**Response to Planning application from Hertfordshire County Council (T and CP GDP Order 2015)**

District ref: 6/2020/1365/FULL  
HCC ref: WH/2321/2020  
HCC received: 22 June 2020  
Area manager: Alan Story  
Case officer: Paul Marshall

34 VINEYARDS ROAD NORTHAW POTTERS BAR EN6 4PA

Erection of a 5-bedroom detached dwelling including formation of new vehicular crossover

Site Plan 1:200

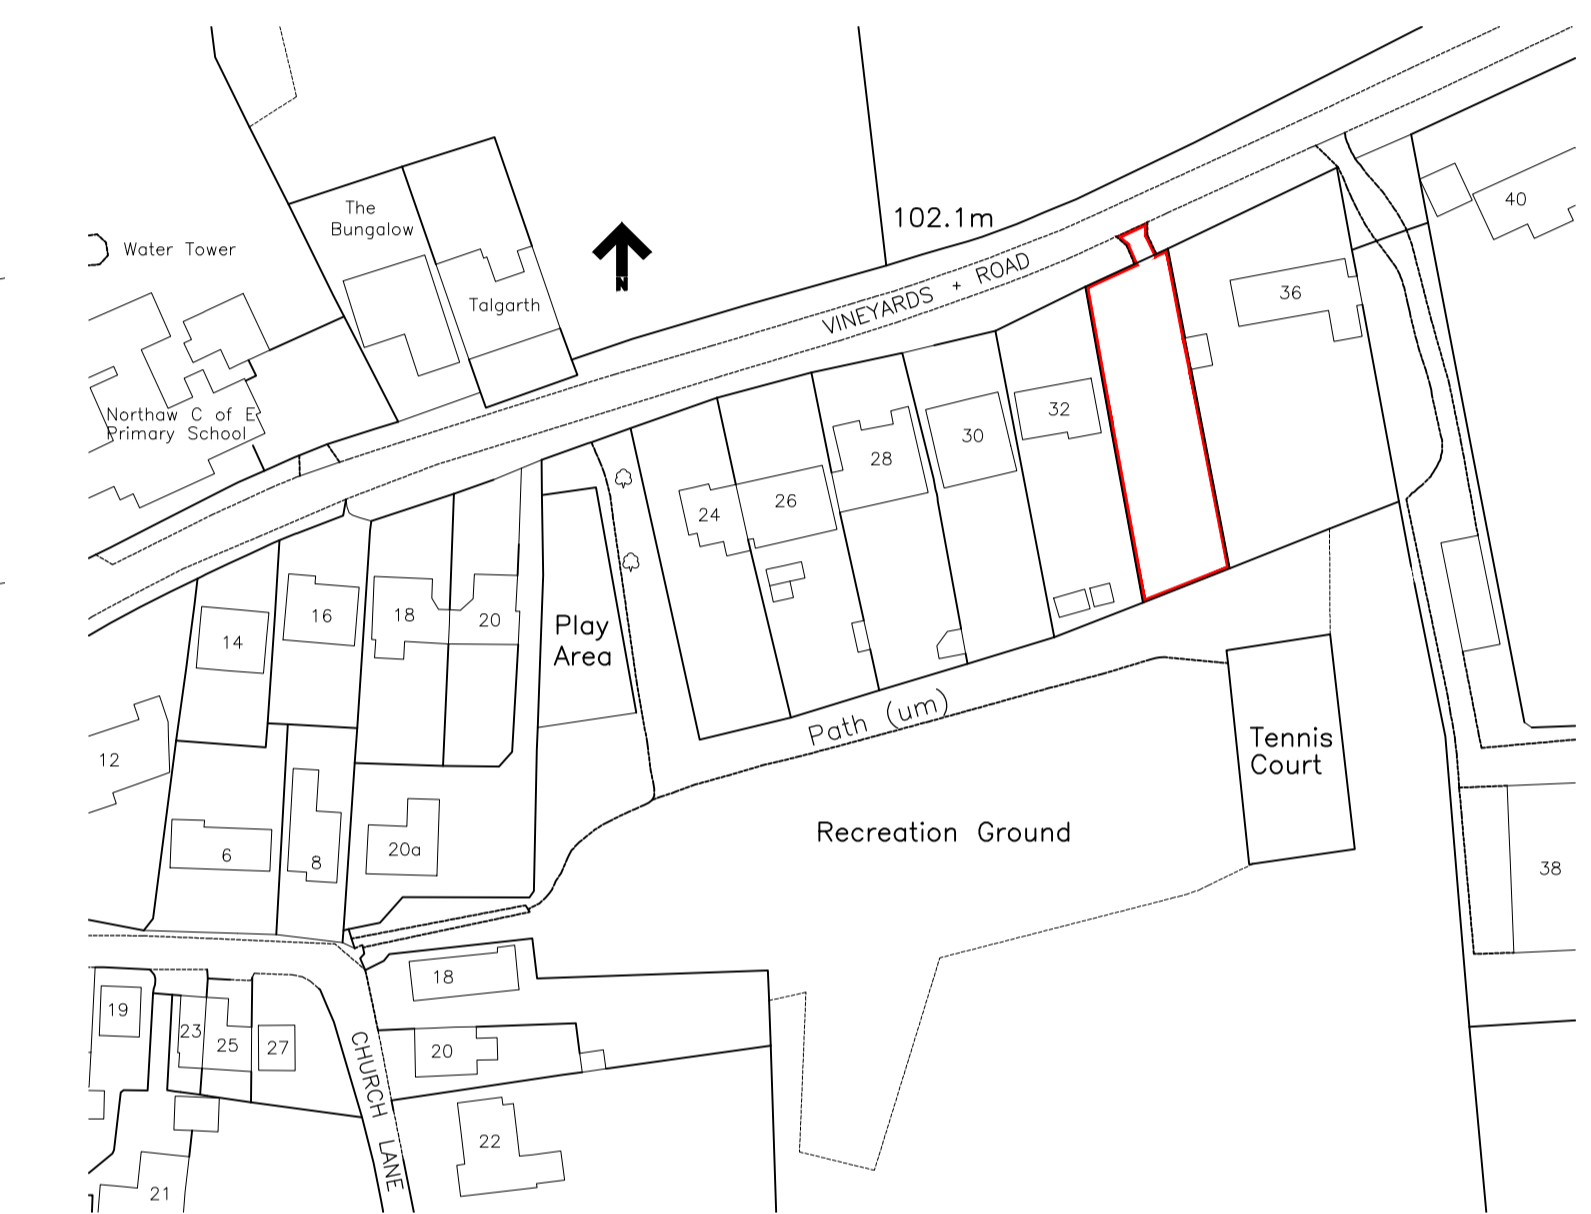
Drawing DPL/20/02-1 demonstrates the proposal are in accordance Manual for Streets 8.3.58, which states 'The recommended dimensions of off-street parking bays are that they are laid out as a rectangle at least 4.8 m long by 2.4 m wide for the vehicle'. Furthermore, vehicles are able to access turn around and egress on to the highway in forward gear.

The proposed new VXO / dropped kerb shown on drawing DPL/20/02-1 would need to be in accordance with HCC's 'Residential Dropped Kerbs: Terms and Conditions' the driveway should be of a bound material to reduce the risk of loose surface dressings entering the highway.

CON1) The gradient of the vehicular access shall not exceed 1:10 for the first 5 metres into the site as measured from the near channel edge of the adjacent carriageway.
